Recommendation Report for Planning Permission for Works or Extension to a Dwelling

REF NO: AW/81/20/HH

LOCATION: 6 Worcester Close
Aldwick
PO21 5QZ

PROPOSAL: Single storey front extension.

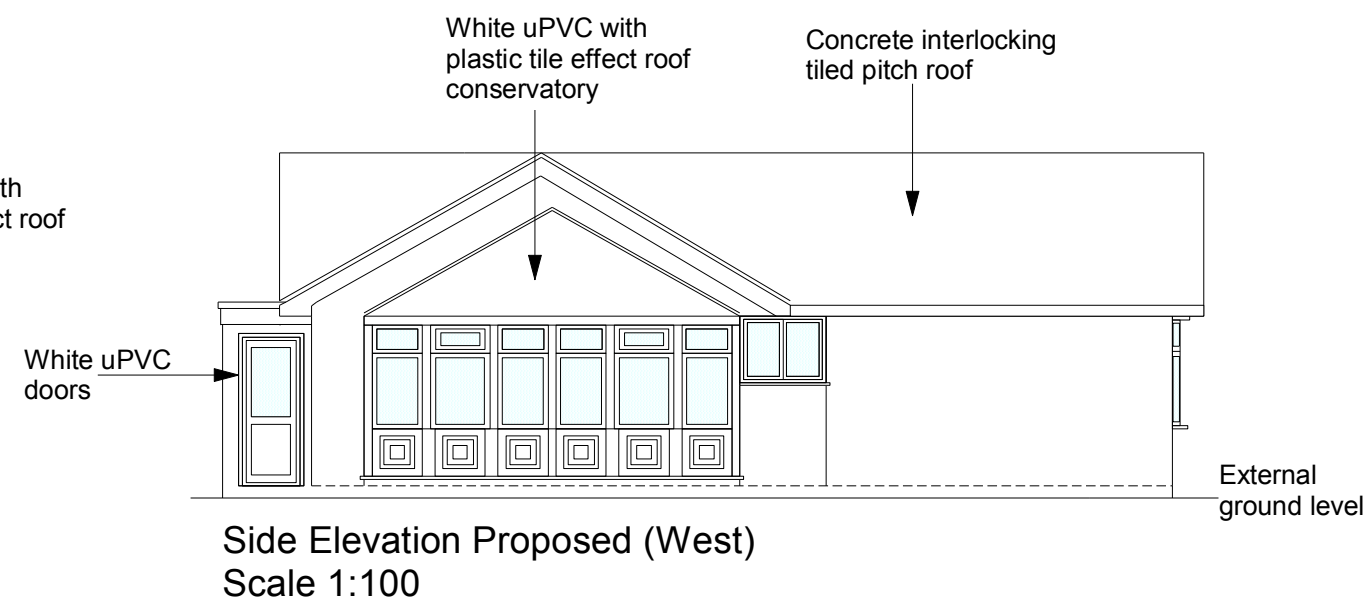
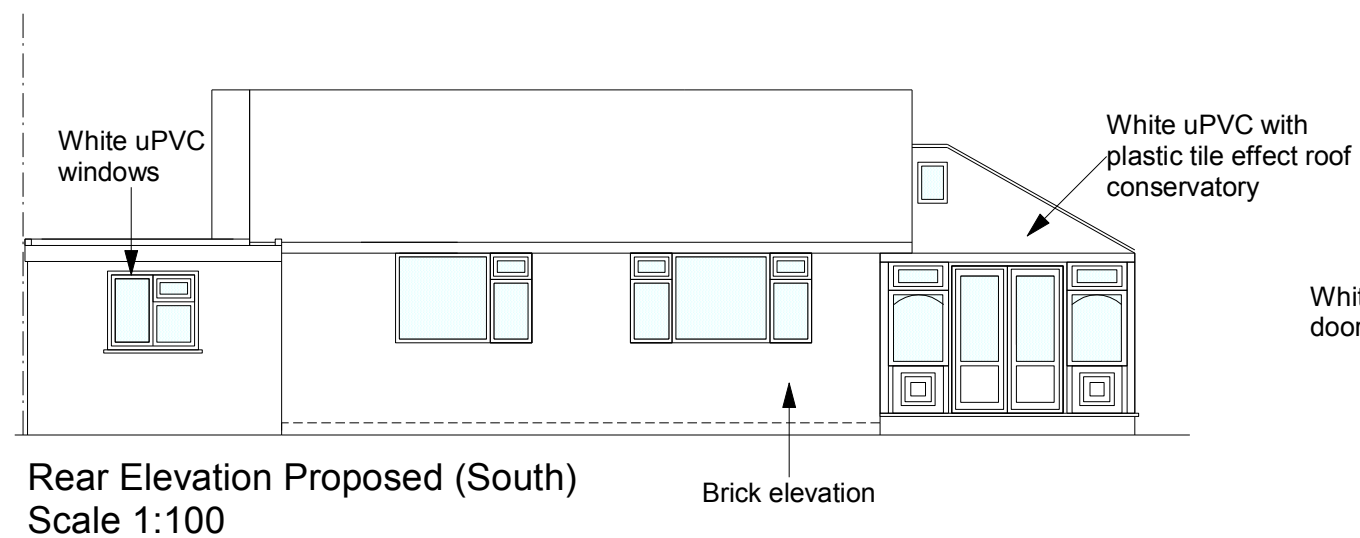
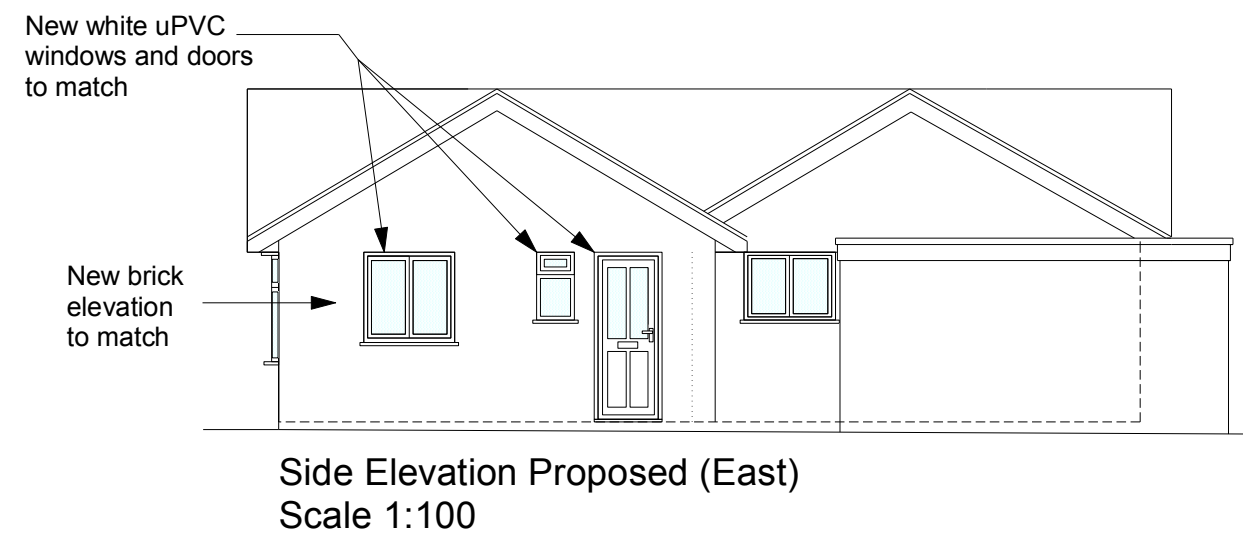
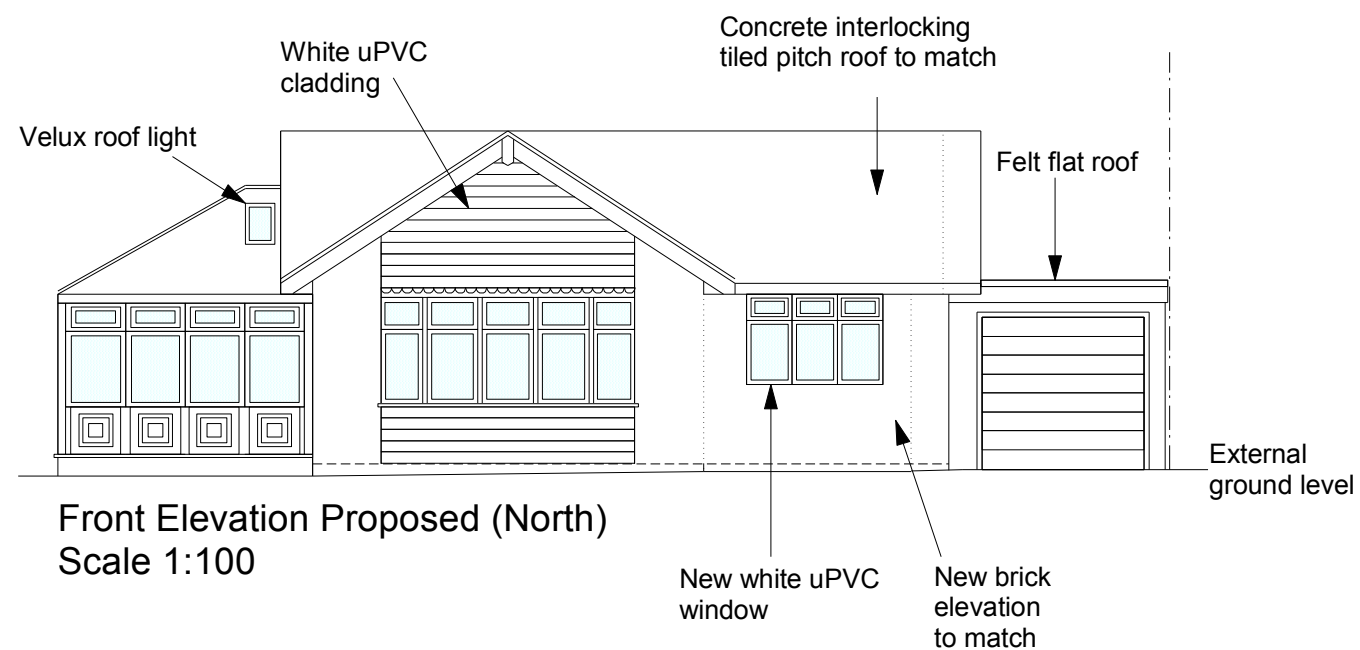
The extension is situated to the front side of the dwelling. The extension will infill part of the northern elevation, meeting in line with the existing gable addition to the front.

The extension will have a pitched roof to match the existing.

The addition whilst fronting the street scene appears subservient and well integrated with the use of matching materials.

The extension does not appear unduly dominant, meeting with the principle elevation and retaining 2.9m is retained to the northern boundary.

The extension will have a width of 3.2m and a depth of 6.6m. The height will be around 4.45m which will meet with the existing dwelling. This will however lean away from the street scene.

There will be 2 windows and a door to the eastern elevation. This will front the neighbouring property however will overlook the front garden and entrance and is not considered to result in views additional to that which are already achieved.
